CBD & SOUTH EAST LIGHT RAIL PROJECT

(RANDWICK CITY COUNCIL & UNSW AREA)

TECHNICAL REVIEW – TRAFFIC ENGINEERING & ROAD SAFETY (DECEMBER 2013)

UNSW Anzac Parade Stop
Diagrammatic Plan 02

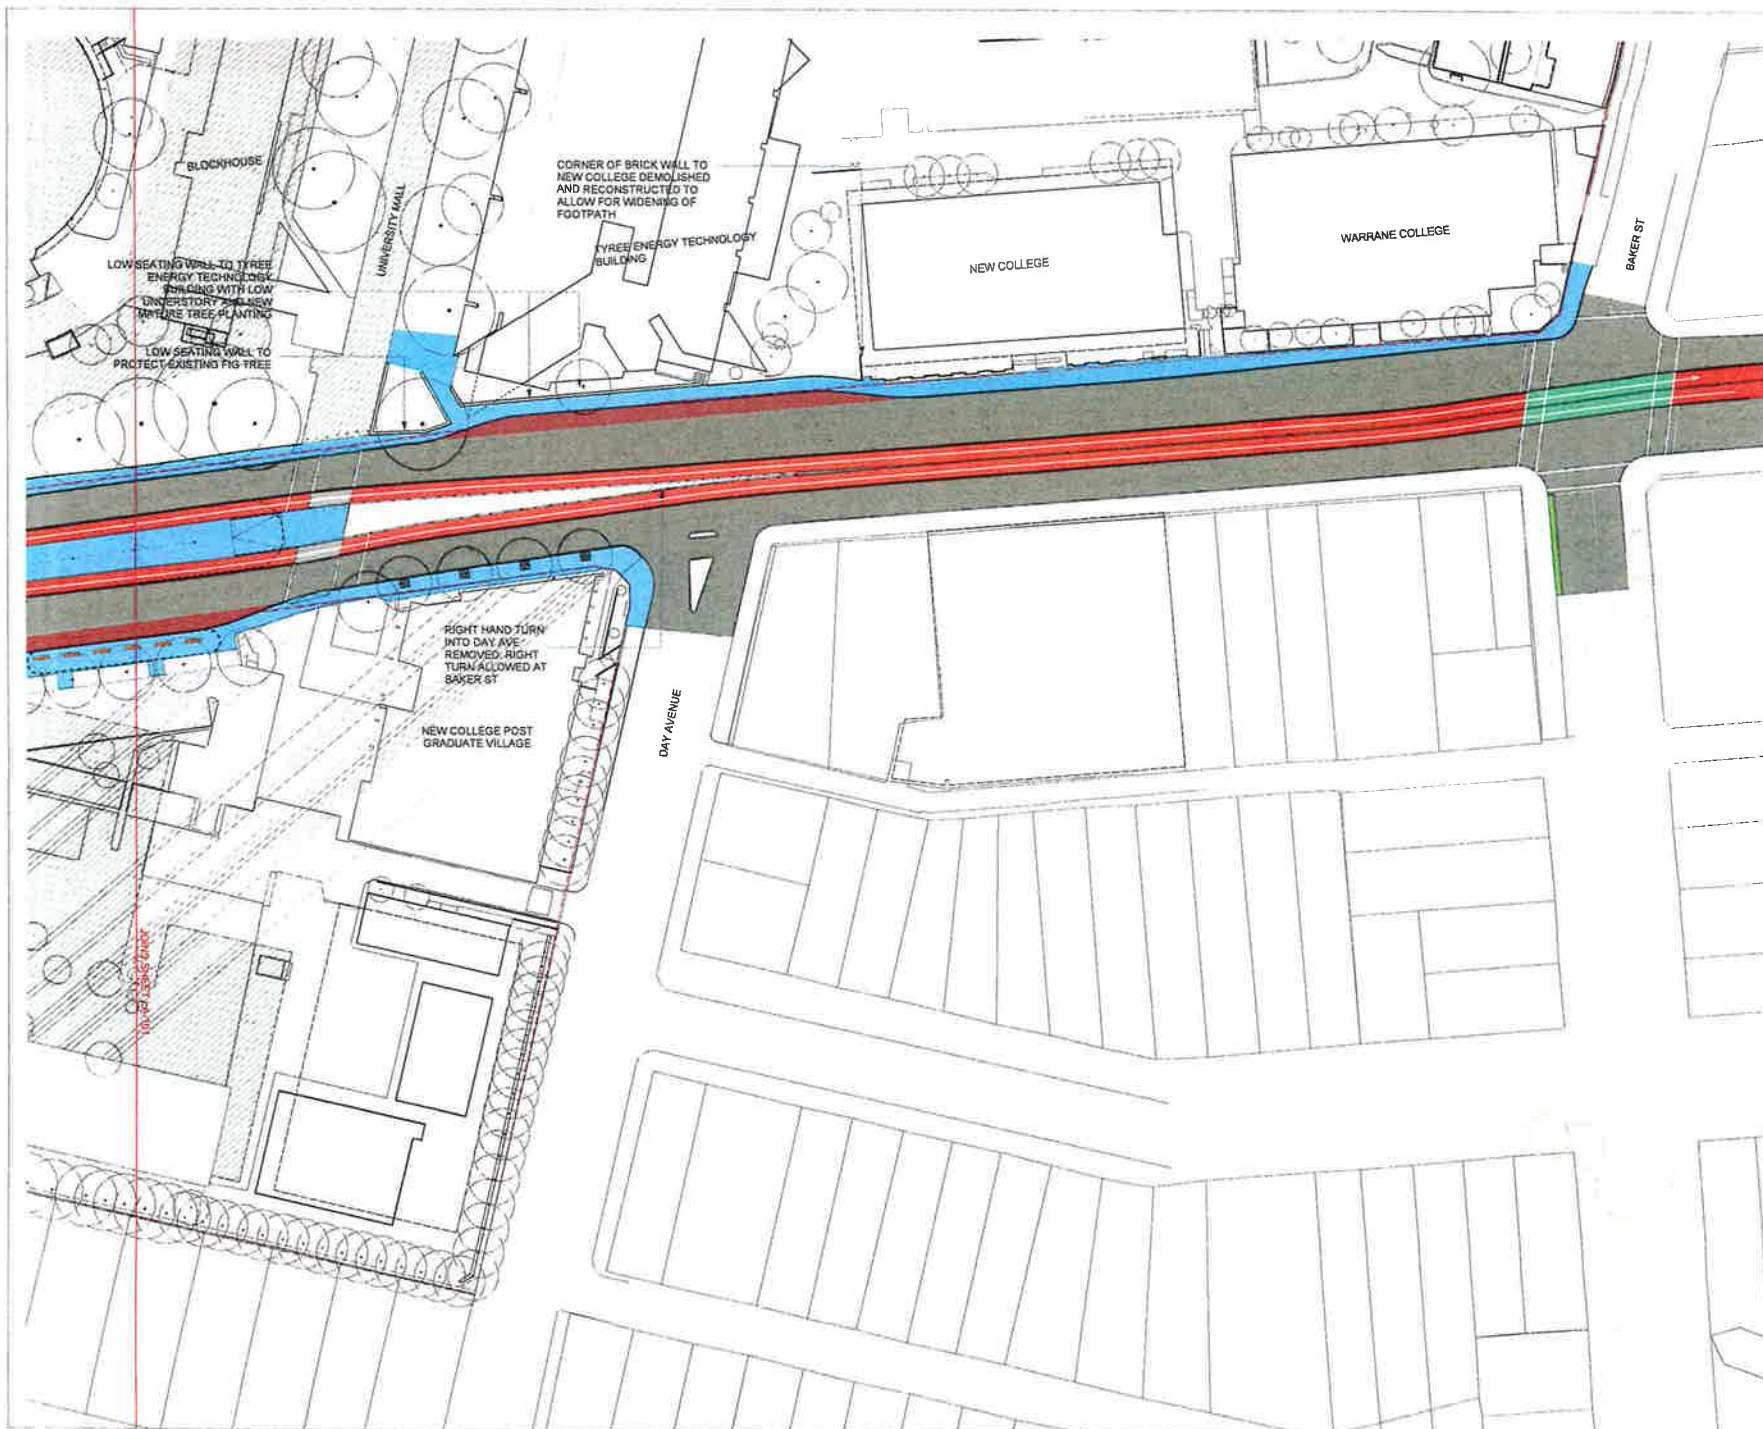
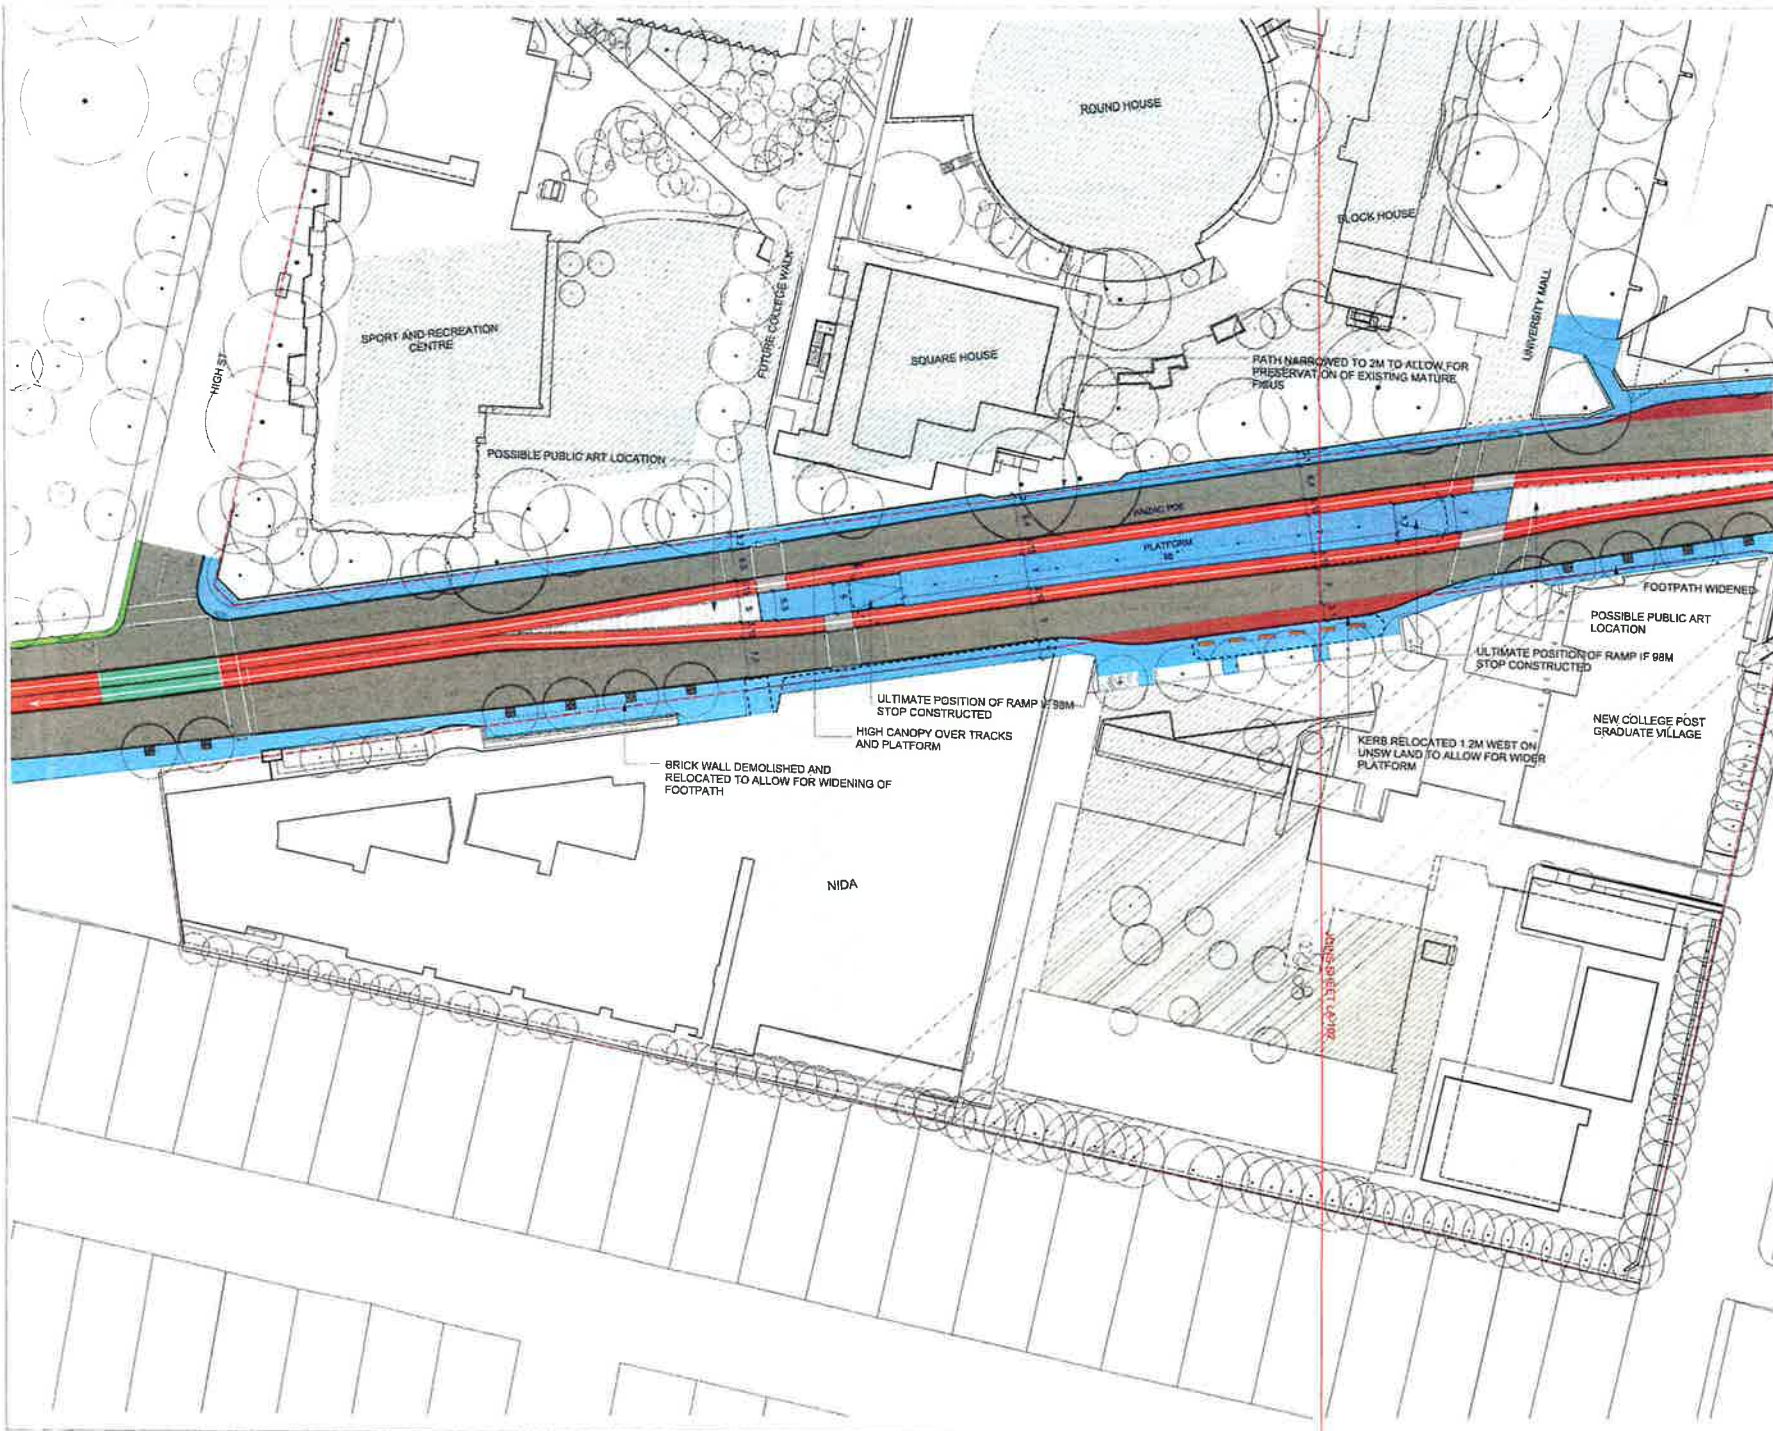
Platform Size	Side platform 45.0m x 3.2m = 144.0 sqm. Island platform 45.0m x 4.4m = 198.0 sqm. The report indicates the need to make provision for future lengthening of stops, but there is not sufficient room at the northern end.	Assumption: LRV at 2-3 minute frequencies at CBD end will result in LRV at 4-6 minute frequencies at this location. Assume approximately 3 LRV each 15 minute period. Alighting: Assuming a capacity of 300 pax per LRV, should be no more than 300 pax alighting at any one time. Capacity of platforms to cater for peak alighting numbers (approx. 898 pax in 15 minute period). Using the Fruin Level of Service criteria, the ramp (average flow rate of 60 pax per minute) is expected to operate with a Level of Service of A. However, if 299 pax alighted from one LRV, the Level of Service would drop to E. Boarding: Capacity of platforms to cater for peak boarding numbers (approx. 1,143 pax in 15 minute period). Using the Fruin Level of Service criteria, this platform is expected to operate with a Level of Service of E (381 pax	Alighting: Proposed southbound platform ramp will lead directly to footpath and will not restrict flow off the stop (subject to proposed fencing arrangements to separate stop from shared path). Congestion may encourage some passengers to use northern pedestrian access. Boarding: Proposed citybound platform will be very congested (Level of Service E/F) with some pax being required to wait on ramp and approaches. The short ramp and limited storage area on the crossing may prevent all passengers being able to access the platform stop at peak times. This will prevent

Category	Sub-Category	Proposed Conditions	Issue / Comment	Potential Alternative / Mitigating Measure
			<p>waiting for LRV).</p> <p>The ramp (average flow rate of 76 pax per minute) is expected to operate with a Level of Service of E.</p> <p>One example of a large centre island platform stop in Melbourne is the Melbourne University stop. This is approximately 6.5m wide and 60m long with ramps and signalised pedestrian crossings at both ends.</p> 	<p>safe passenger circulation along the stop.</p> <p>Design track layouts to provide for future lengthening of citybound stop.</p> 
	Storage	Ramps provided at both north and south ends to provide access.	The short ramp and limited storage area on the crossing to the citybound stop may prevent all passengers being able to access the platform stop at peak times. This will prevent safe passenger circulation along the stop.	Review size of platform stop and length of ramp to cater for peak passenger loads.

Swept Paths	Nil.	LRV and buses will create wider swept paths as they undertaken turns to and from the centre of the road.	Review swept paths of turning LRV and buses.

LRV	<p>LRV Priority crossings at both ends of stops. University Mall Pedestrian Operated Signals located approximately 30m south of southern stop crossing.</p> <p>NB: Stop line for Pedestrian Operated Signals should be located 6m back from crosswalk.</p>	<p>Southbound LRV will need to 'trigger' LRV phase to cross back to centre of road. There is not enough length between stop and Pedestrian Operated Signals for LRV to store without blocking southern crossing.</p> <p>A second northbound LRV could follow another LRV through the Pedestrian Operated Signals as there is just enough room for it to store clear of the Pedestrian Operated Signals. However, the second northbound LRV would reduce visibility to pedestrians using the Pedestrian Operated Signals.</p> 	<p>Review how southbound LRV will 'trigger' tram phase.</p> <p>Review storage of southbound LRV between stop and POS.</p> <p>Review storage of northbound LRV between stop and POS.</p>

Signal Pedestals	There is no room between either the two directions of traffic or between the southbound traffic lanes and the northbound light rail tracks.	<p>There is no room available for signal pedestals to be located next to the southbound traffic. Large mast arms will be required. The height and location of the large mast arms will need to consider the overhead light rail wires.</p> <p>The complex movements required at the intersection of the Pedestrian Operated Signals would also benefit from adjacent signal pedestals. However, large mast arms are likely to be required.</p>	Review layout to create space for signal pedestals
	Crossing Points	LRV priority crossings are shown at the north and south ends of the stops.	<p>As shown on the Stop Plan, the crossings do not need to extend on to the northern Light rail tracks.</p> <p>Access at the northern end is important if land use within UNSW changes and provides an alternative access/egress to the stop during peak times.</p> <p>LRV Priority Pedestrian Crossings are proposed. In Melbourne, the signs used in these instances are 'Give Way to Trams'. With the high number of pedestrians and complex movements for the LRV, static signs may not be enough. Could consider supplementary LRV-activated LED signs to warn of approaching LRV.</p> <p>Important to used different materials to indicate LRV areas and pedestrian waiting areas.</p>	Remove crossings across northbound tracks. Install a fence along the east side of the northbound tracks.

Ramps	DDA compliant ramps provided at both north and south ends to provide access.	The ramp ends at the crossing points which may create congestion as pedestrians wait to cross the southbound track.	Shorten ramps if possible to create larger waiting areas.
Access	Illegal Access	No pedestrian fencing shown.	Existing pedestrian fence is located in the centre median adjacent to the Pedestrian Operated Signals. Illegal pedestrian movements to and from the platform stops is likely.	Consider the installation of pedestrian fencing adjacent to the citybound LRV track.
	Safety	-	Illegal access is the main safety issue as discussed above.	Nil.
	Footpath / Shared Path	Wide footpath to be provided along east side of tracks.	Footpath along east side of Anzac Parade used as a bicycle route.	Consider barrier along outside of side platform to prevent people from just walking out on to shared path and creating
